Recommendation Report for Planning Permission for Works or Extension to a Dwelling

REF NO: FP/41/21/HH

LOCATION: 17 Bala Crescent
Felpham
PO22 8LY

PROPOSAL: Single storey rear and side extension to provide family room, utility room and WC.

DRAWING TITLE
PROPOSED SIDE (WEST) ELEVATION

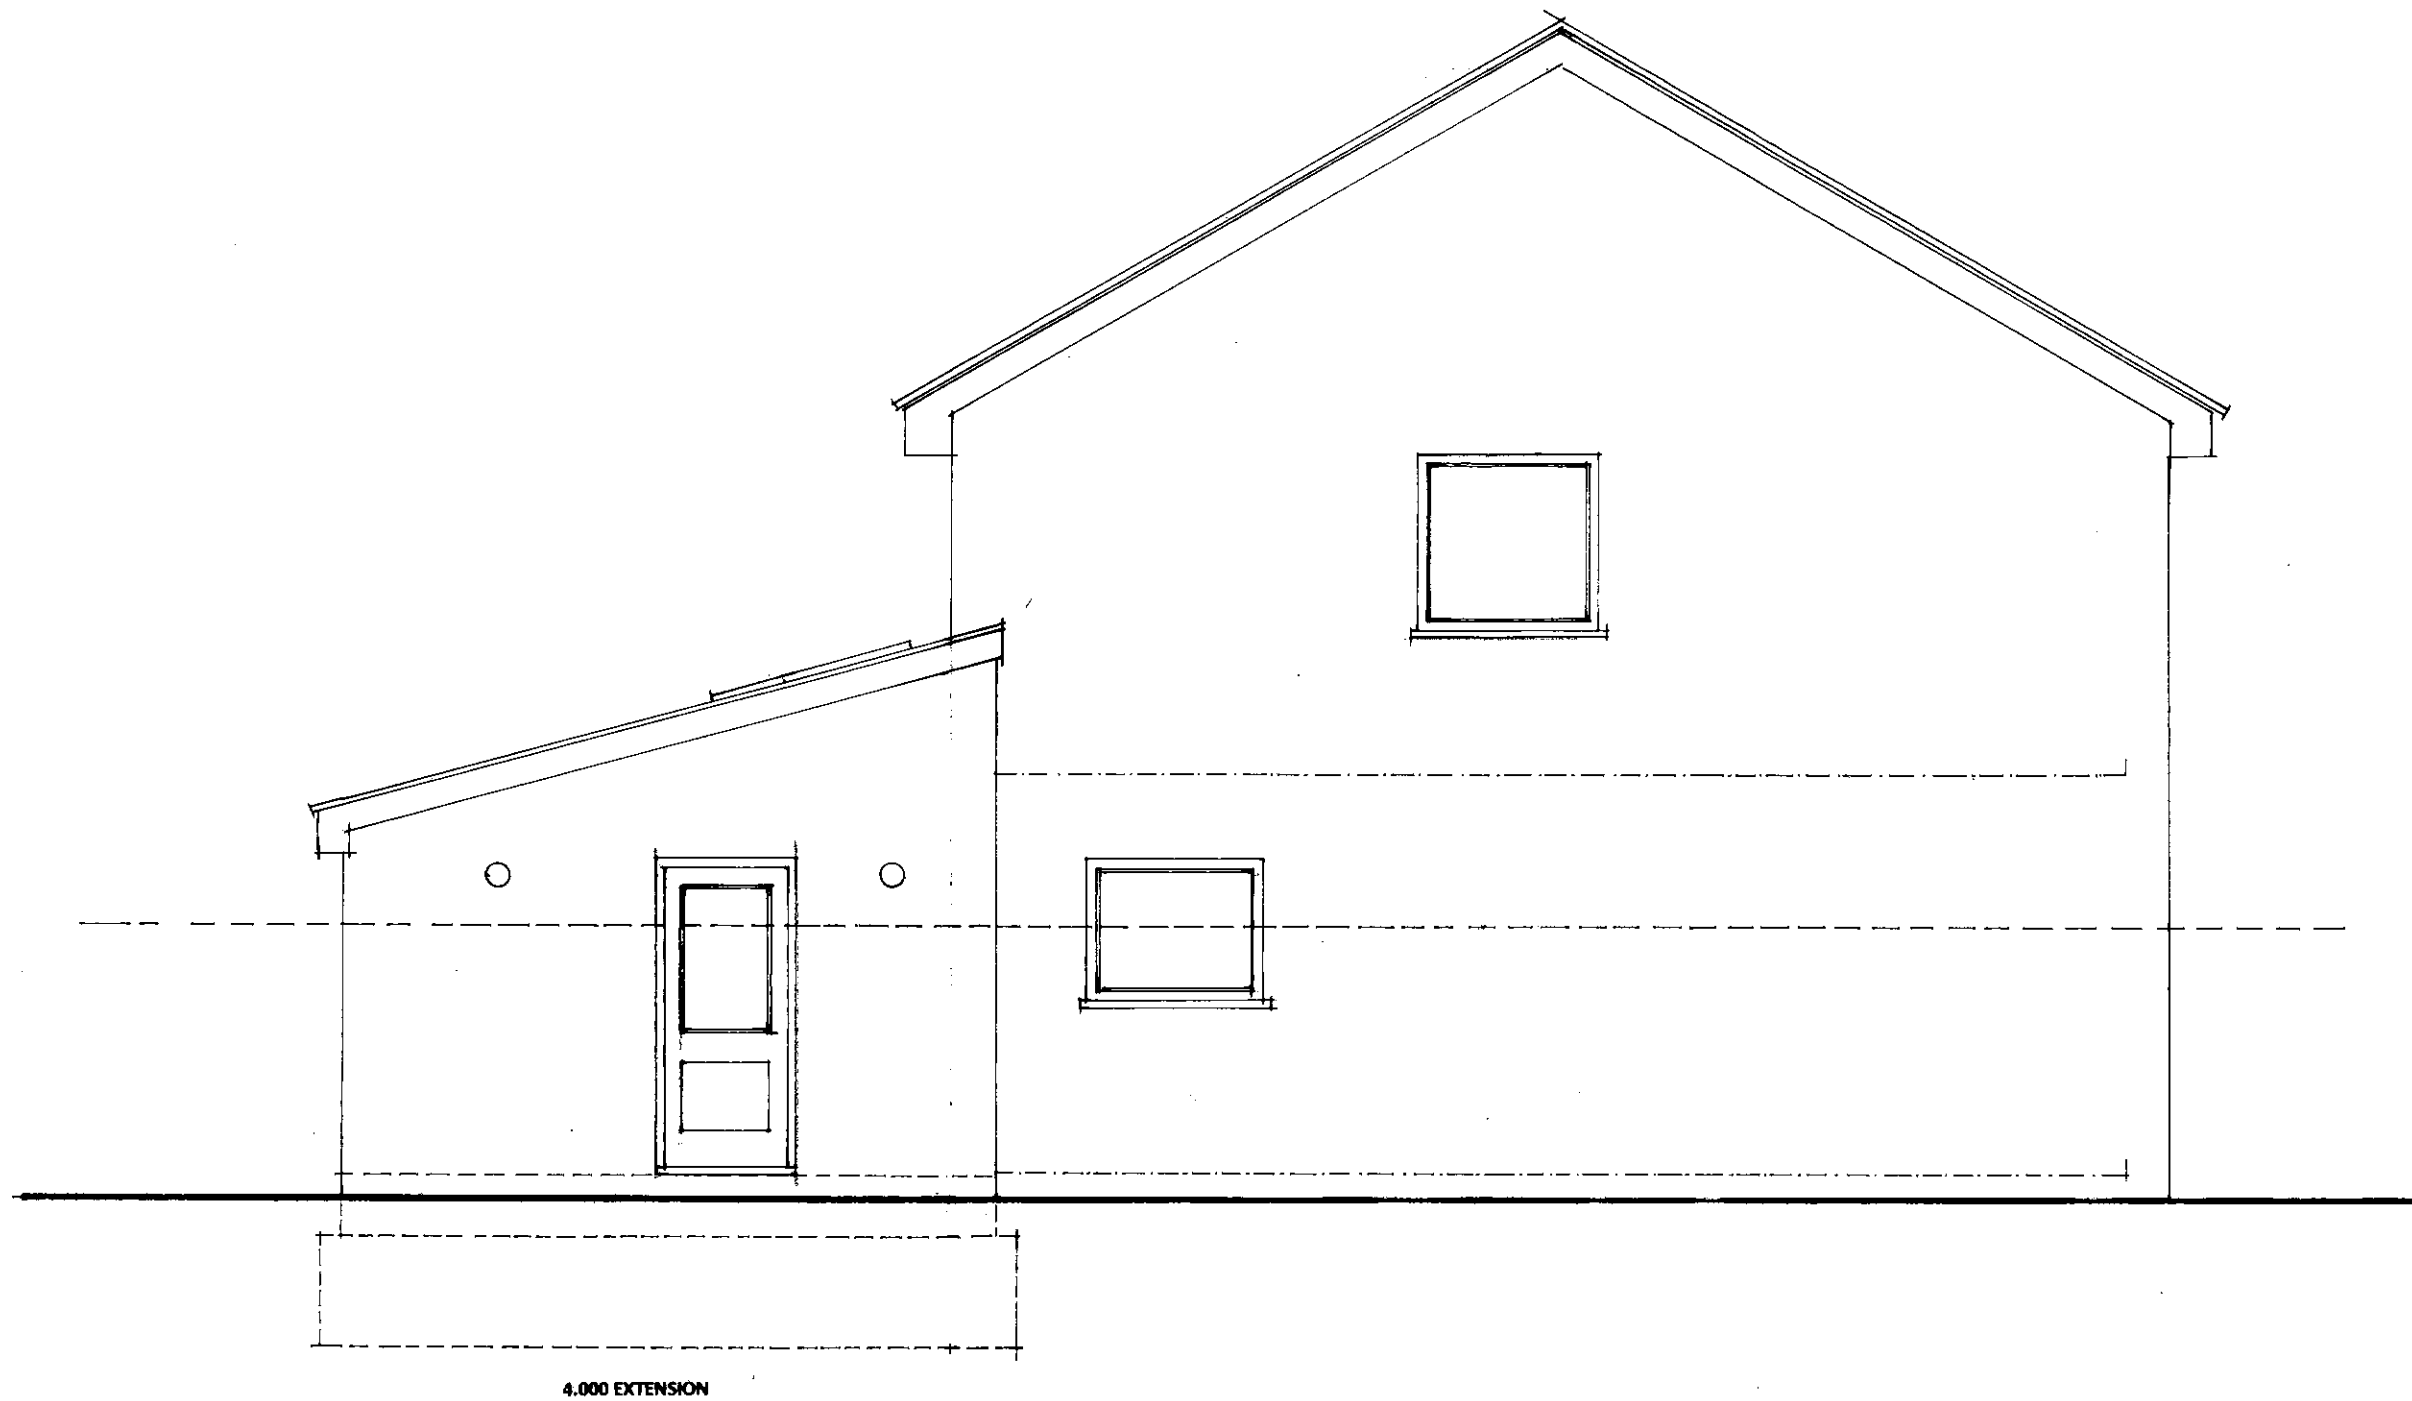
The single storey rear and side extension will have a width of 6.96m, a depth approximately 4.0m and a height of approximately 3.75m to the pitched roof. There is 1m to the western boundary of property. Due to the siting of a door on western extension elevation it will not cause overlooking to neighbouring properties due to the extension at single storey and the existing western boundary fence restricts views.

Whilst the proposals will increase some overshadowing to the west, the gap of 1m remaining to western boundary and boundary fence will reduce effects of overshadowing so is considered acceptable. Whilst the siting of the proposals within 1m of the eastern boundary does not comply, the proposals being at single storey and the location of the existing boundary fence reduces impact of overshadowing effect so is deemed acceptable.

DRAWING TITLE
PROPOSED ELEVATIONS

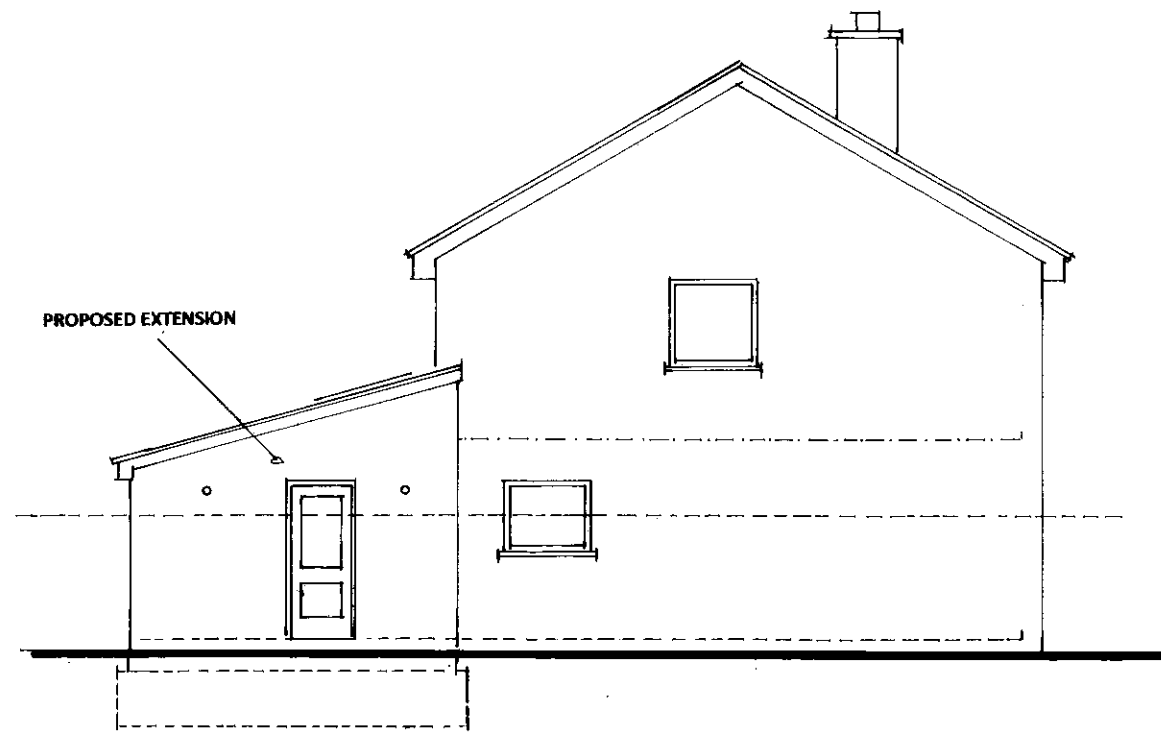
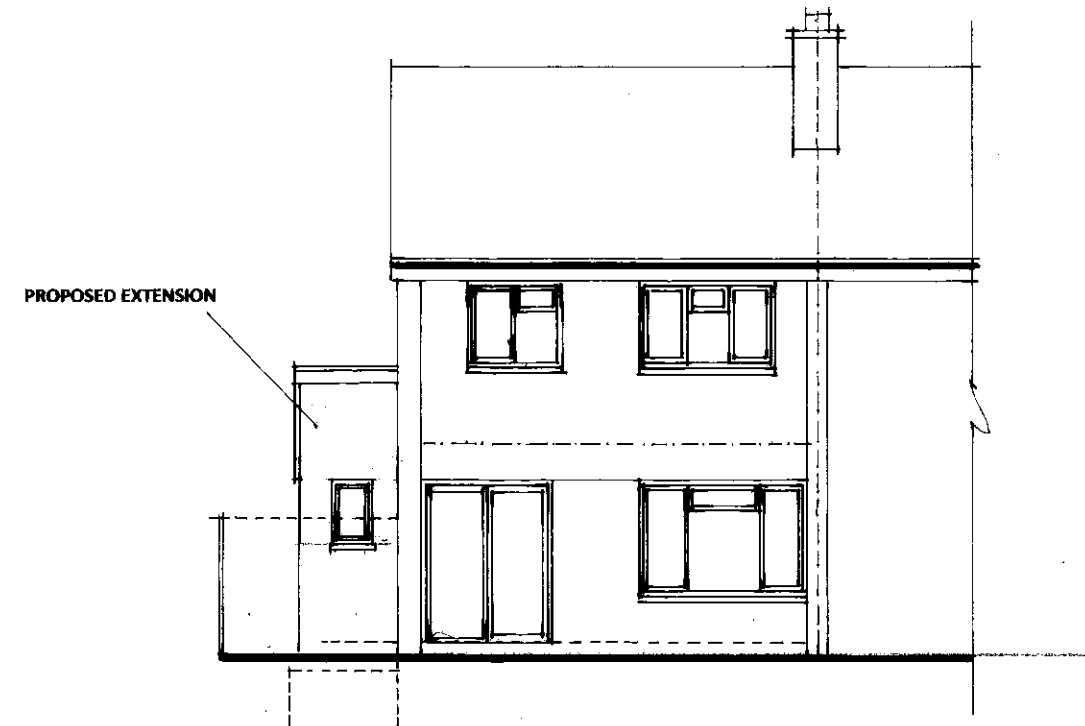
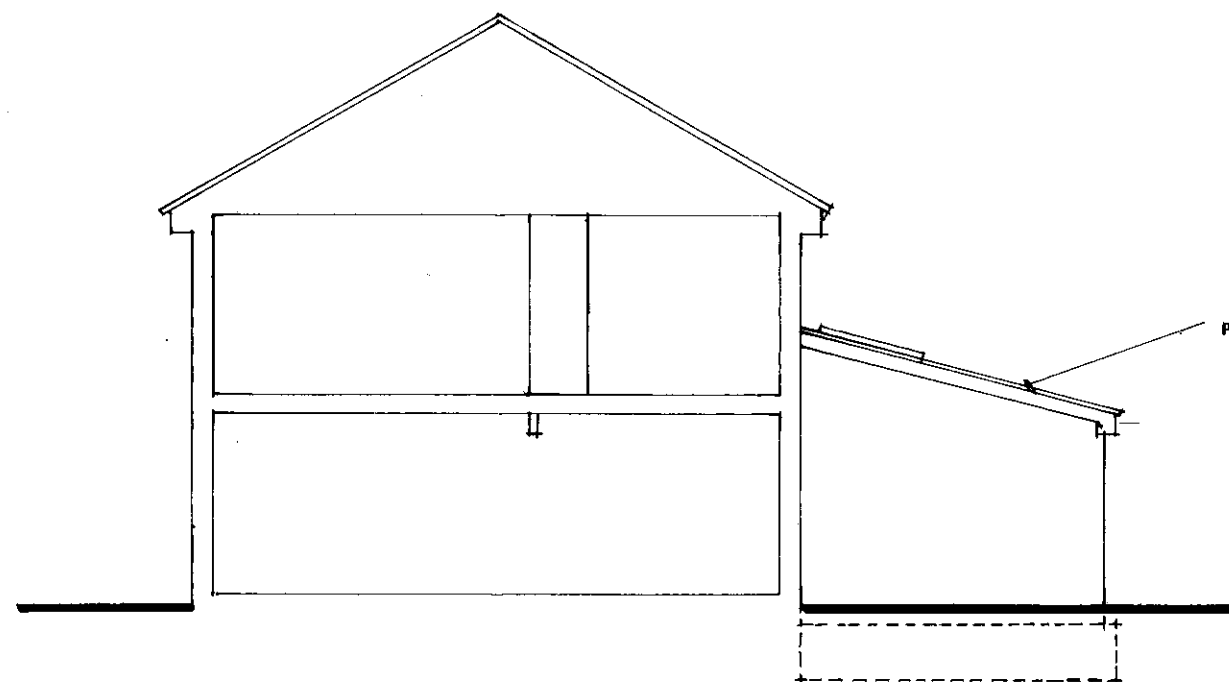
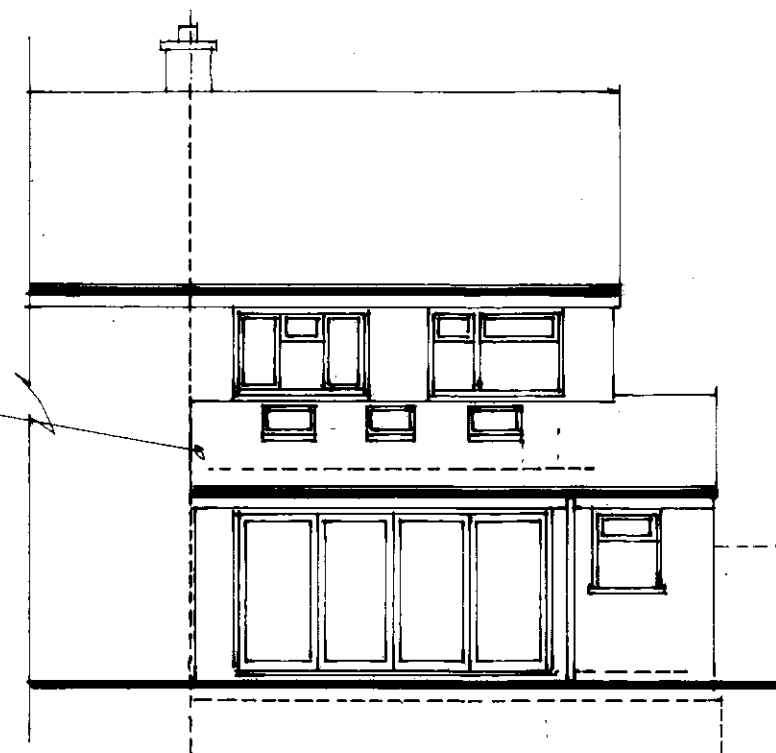
The proposed materials will match existing and seem to match appearance of existing dwelling. The proposed materials seem to visually integrate with the existing dwelling so comply with D DM4 of the Arun Local Plan.

The window in the southern extension elevation faces the driveway. Due to no direct neighbours to the south there is no adverse impact to overlooking to the street scene. The new proposed bi-fold doors and single window on the northern elevation of extension face the garden. Due to the large gap of 11.0m remaining to rear of garden there is no harm to overlooking to neighbours at rear of property and the extension is sited beyond existing building line to west so no harm of overlooking to neighbouring property to the west. The extension will not have adverse overlooking effects to east due to being at single storey and no windows proposed in east elevation of extension so complies with Policy D DM4 of the Arun Local Plan.
